City of Albuquerque Stormwater Construction Site Inspection Report

ESC File No.	M10E020	Project Name:	Kidz Academy and The Human Bean		
NPDES Id. No.	NMR1003NO/NMR1003NP	Location:	7800 Sage Rd. SW		
1/26/2022	Owner	Contractor			
Operator	Kidz Academy and Tres Lobos	Creative Design Builders			
Contact name & title	Keith Griego	Raymond Herrera			
e-mail	kidzacademystaff@gmail.com	rhcdb46@yahoo.com			
Contact Phone #	505-681-7812	505-410-9020			
COA Inspector	Doug Hughes	Start/End Time:	4pm		
Construction Phase:	Vertical				
Type of Inspection:	Regular	Storm Event	Past Storm Event >0.25"	311/Complaint	Follow Up
Weather at time of inspection?		clear	Temperature: ~		40
Estimated date of last storm 0.25" or greater		1/1/2022

TEMPORARY EROSION AND SEDIMENT CONTROL PLAN

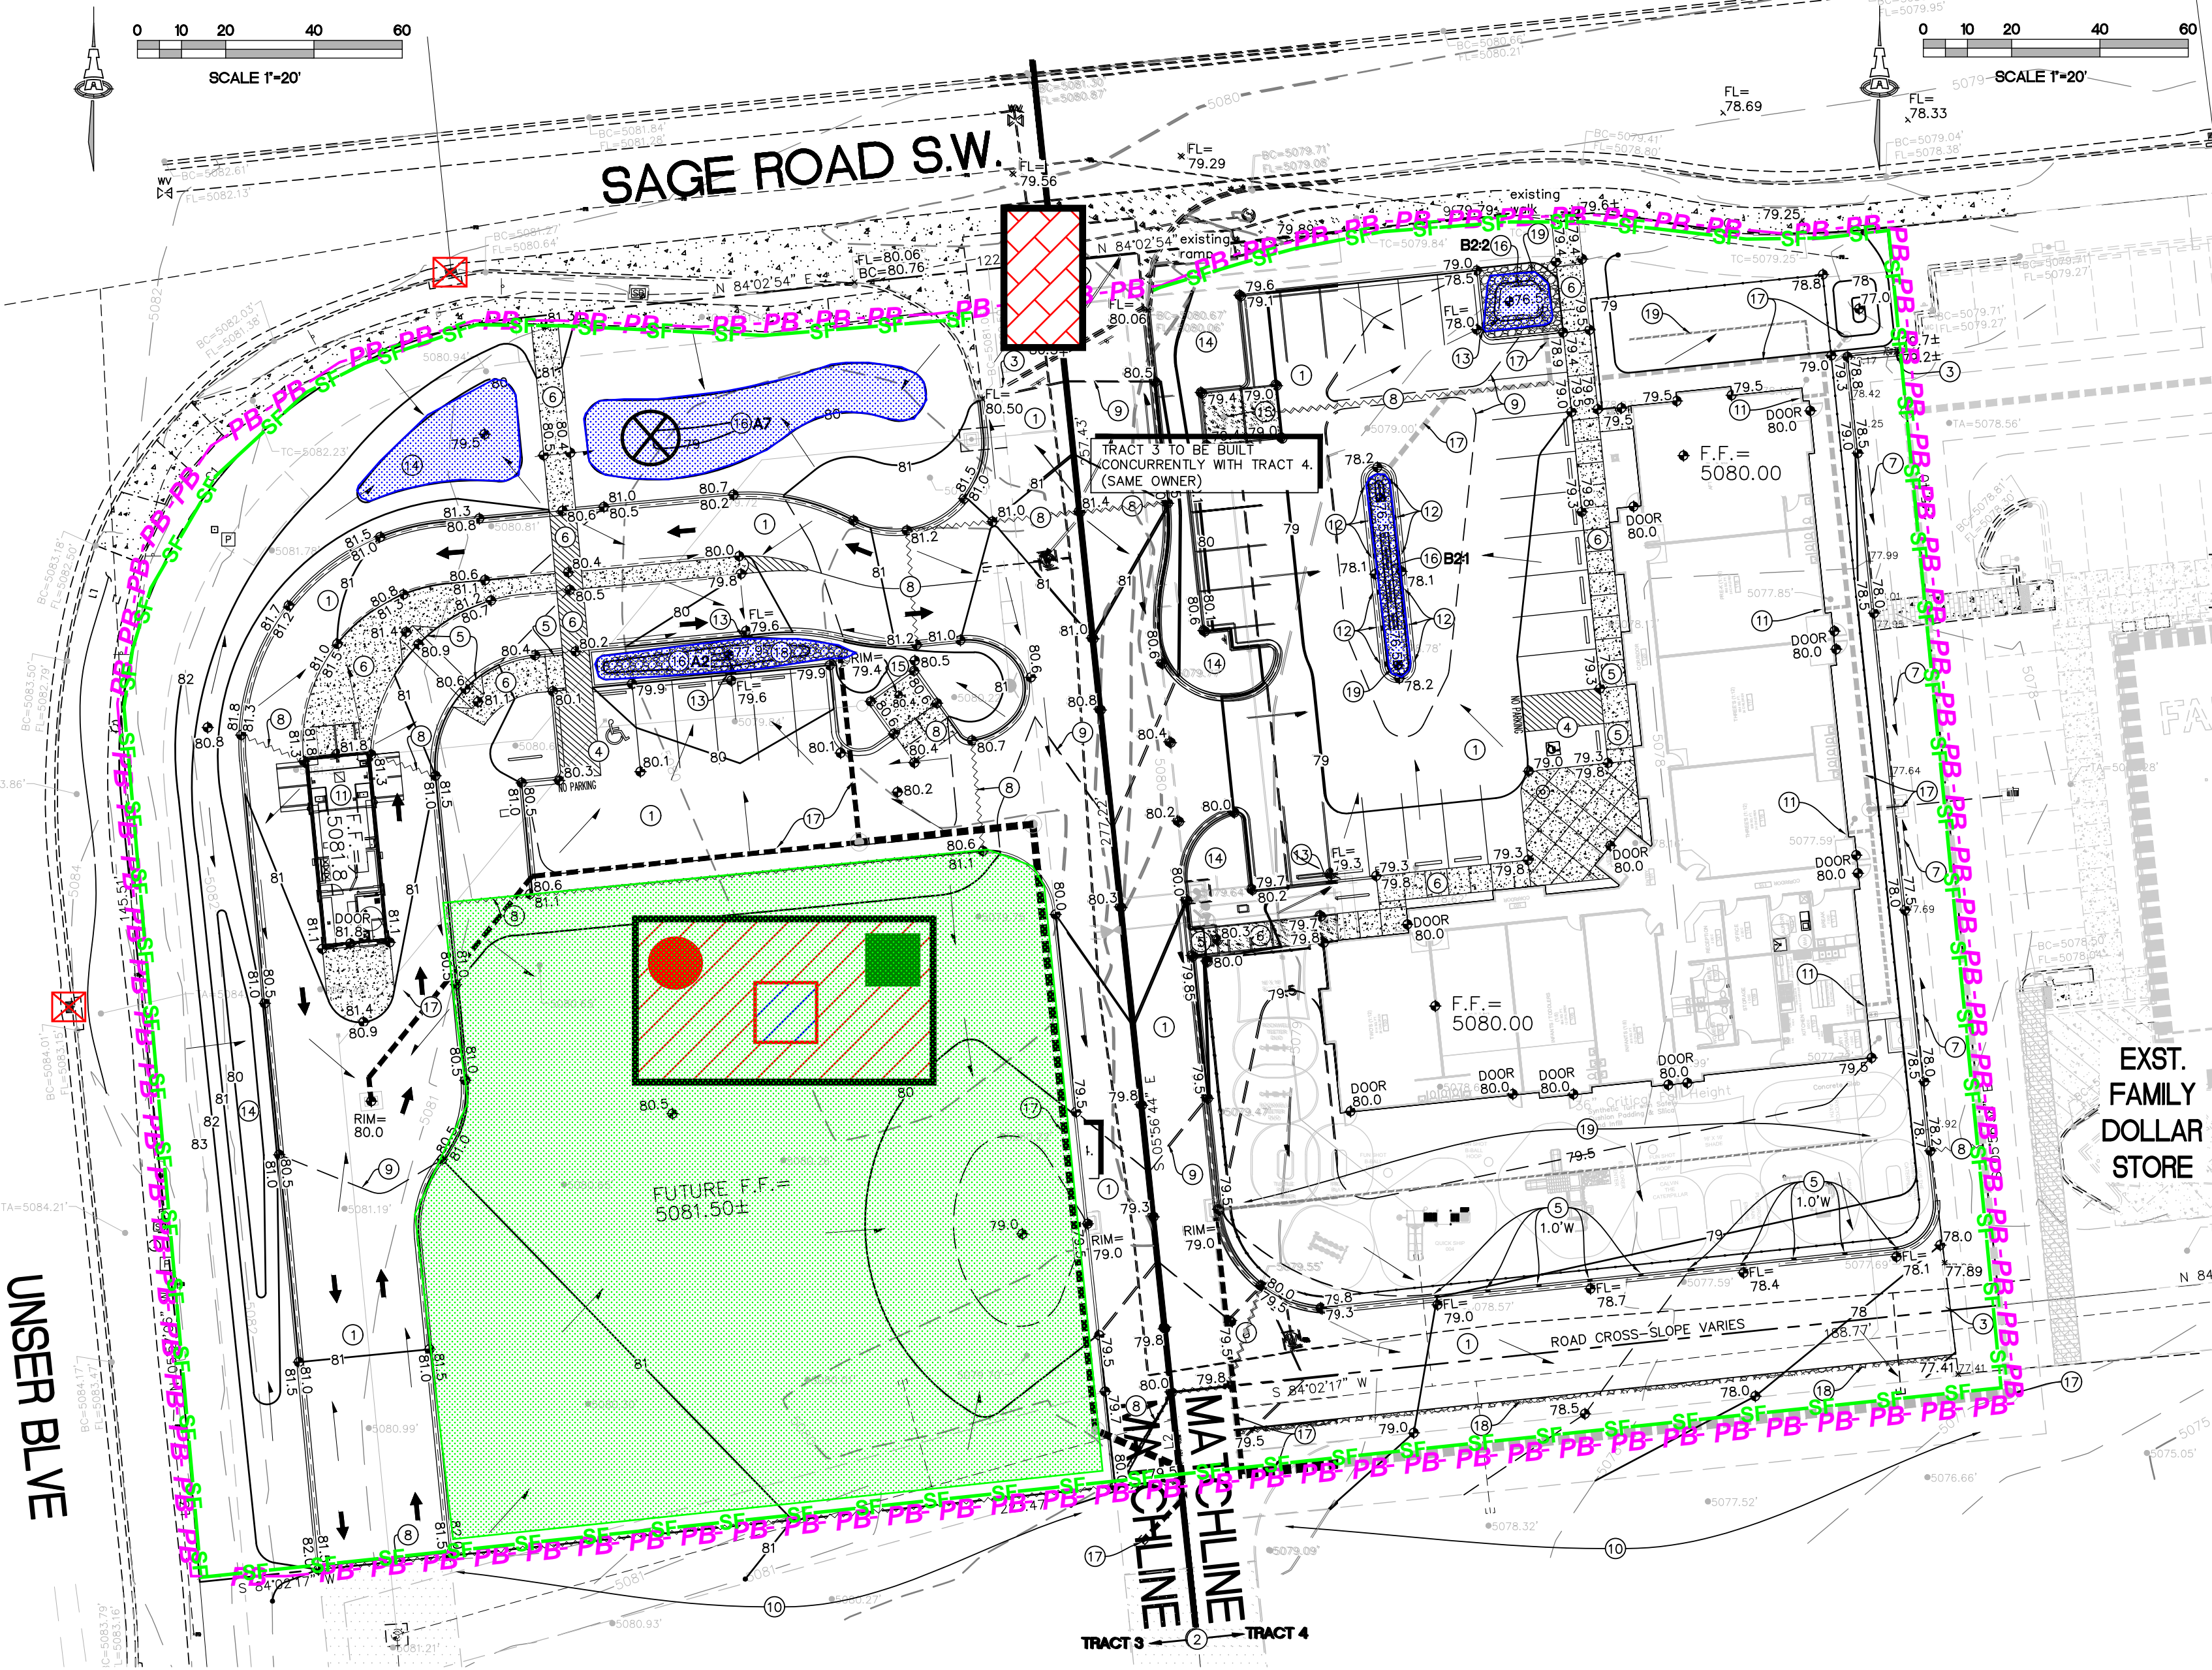
Item Number	Deficiency/ Corrective Action				
1	Inlet Protection in Sage downstream of the site is not maintained and and there is too much sediment in the street upstream of the inlet. Sediment must be removed from Sage and from the parking lot east of Kidz Academy and the inlet protection reset.				
2	Silt fence is missing. The areas of disturbance south of the site, both onsite and on the adjacent property must either have silt fence or final stabilization, and the debris removed in a covered waste container.				
3	The SWPPP wasn't available and its location wasn't identified on the sign because the sign was missing. Last inspection - 1) Reports were not signed by Operators or Delegated Authority 2)swq team not per CGP 6.1. The SWPPP mis be u-to-date including the map, and be accessable onsite, its location posted.				
4	Posting of NPDES Permit coverage was missing and must be posted for safe public viewing for all three operators.

Notes:	
Human bean looked like it is open for business but signs missing, Kidz academy is nearly complete. Incomplete stabilization, lack of posting, sediment, and missing BMPs must be mitigated. Raymond said he couldn't get it all done by Monday so an extra week is being allowed.
